FP/16/19/PL
1A Wood Hill Way

Description of Works: Change of use from shop (A1 Shops) to coffee shop selling coffee & sandwiches (A3 Food & Drink).

FLOOR PLAN

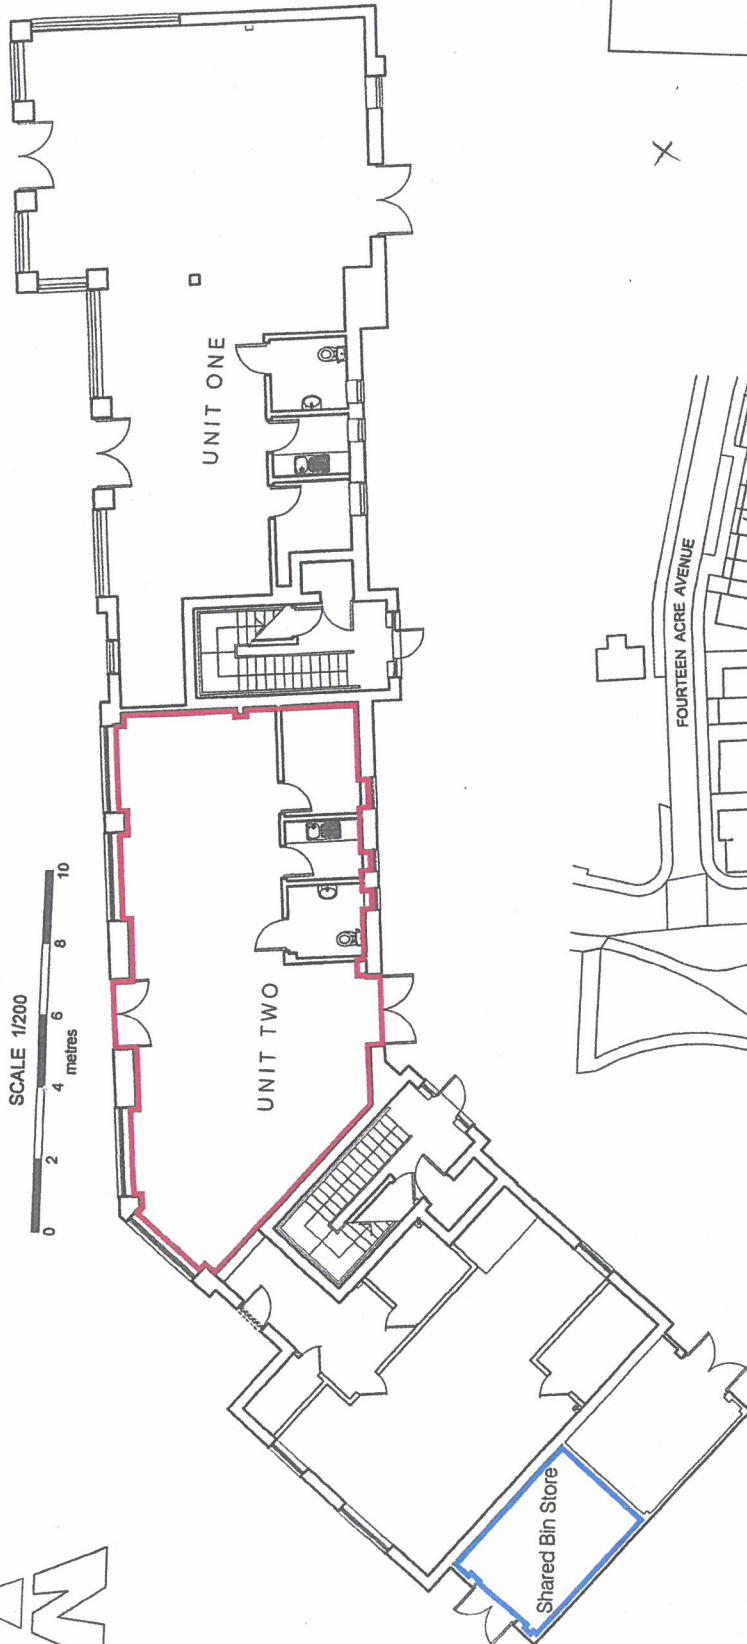
2. Cooking odours – The application is to change the use to A3 which includes restaurants and the proposed floor plans show an oven on site but there is no mention in the application of how any cooking odours are to be dealt with. I would therefore recommend the following condition;

should also note that toilets should not lead directly into rooms in which food is being prepared or eaten. This means that there should be a lobby with two doors between the lavatory and the food room, and is required by European Food Law. The proposed floor plan does not show a lobby between the WC and the dining room. I recommend including the condition below.

The use hereby permitted shall not be carried on unless and until details of a suitable system for the extraction and disposal of cooking odours (including details of the extract fans, filters, fan units and ducting together with method of noise abatement, as well as details of grease traps and extraction hoods) has been submitted to and approved in writing by the Local Planning Authority. The equipment approved under this condition shall be installed before the use hereby permitted commences and thereafter shall be maintained in accordance with the manufacturer's instructions.

The use hereby permitted shall not be carried on unless and until details of a suitable provision of sanitary accommodation Council document entitled: 'Provision of sanitary accommodation in food businesses') has been submitted to and approved
